# **FINAL DRAINAGE REPORT – ADDENDUM NO. 1**

## **ARACO ENTERPRISES LLC - BUILDING ADDITION 7470 SOUTHMOOR DRIVE, FOUNTAIN, CO**

**JPS Project No. 111705  
PPR-1950**

DETENTION BASIN A1 DETAILS

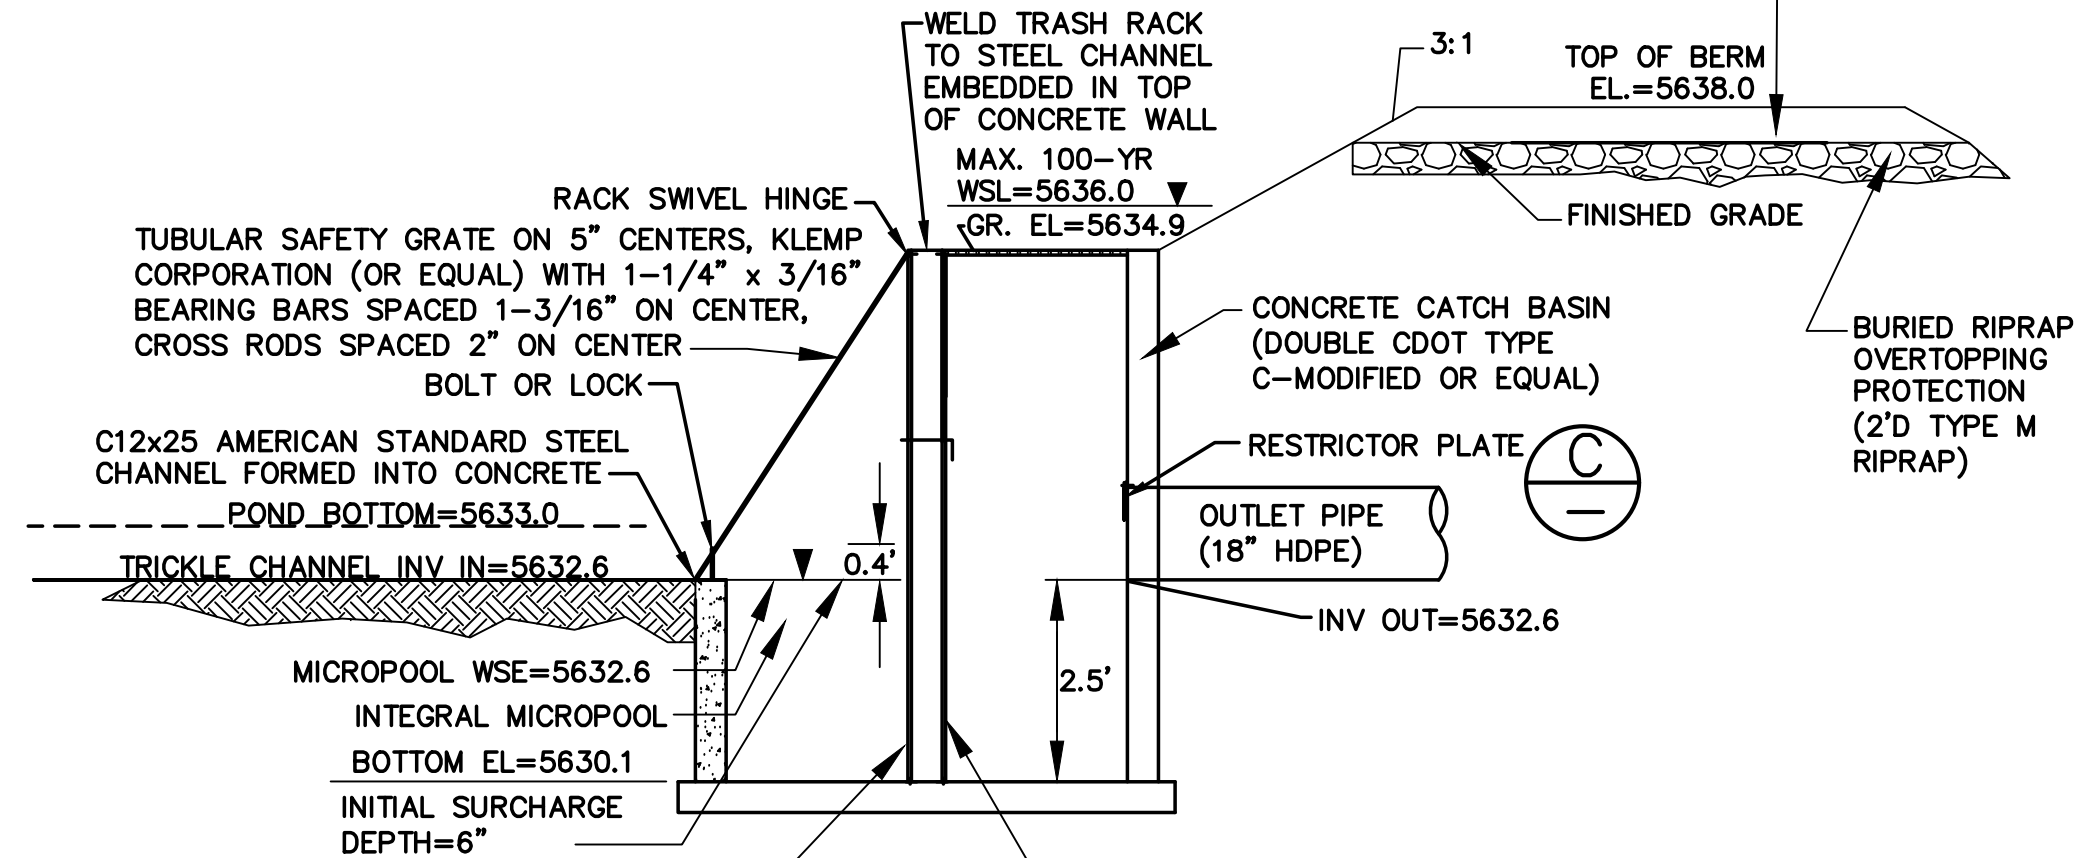
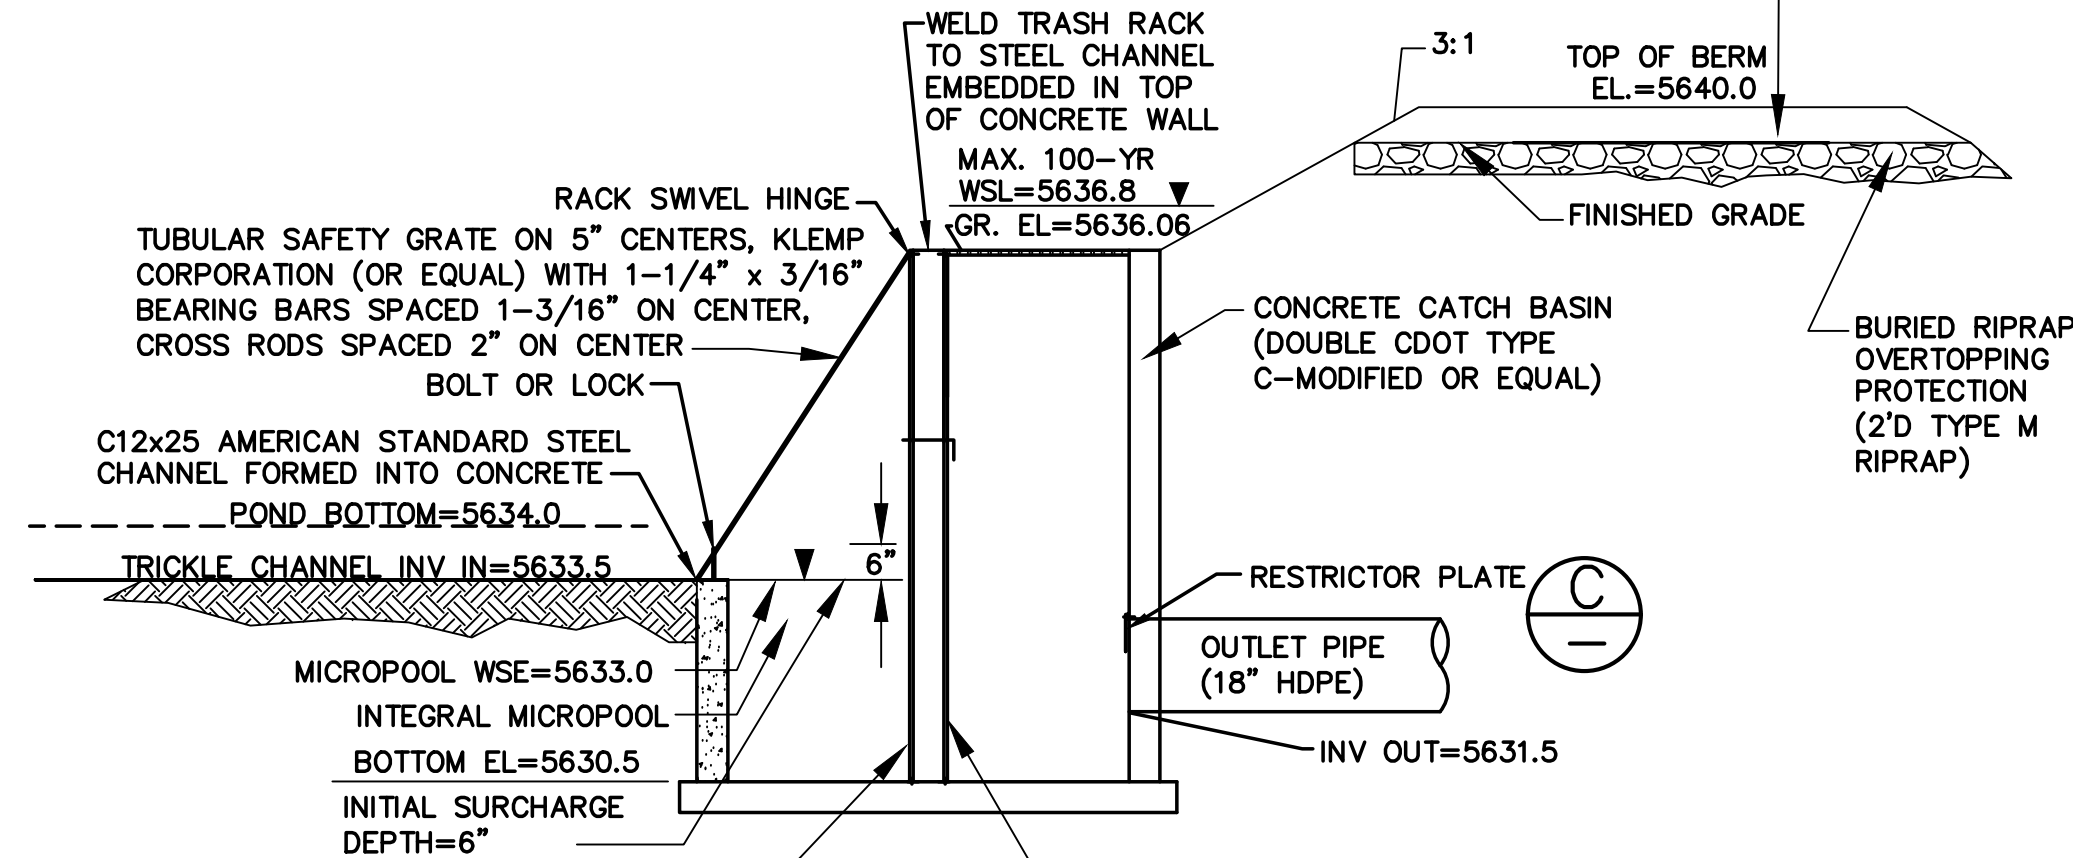
15/16" diameter will result in an Orifice Area of 0.69 sq. inches. Update spreadsheet, or increase the diameter to 1" (0.79 sq. inches) and update spreadsheet and GEC Plans
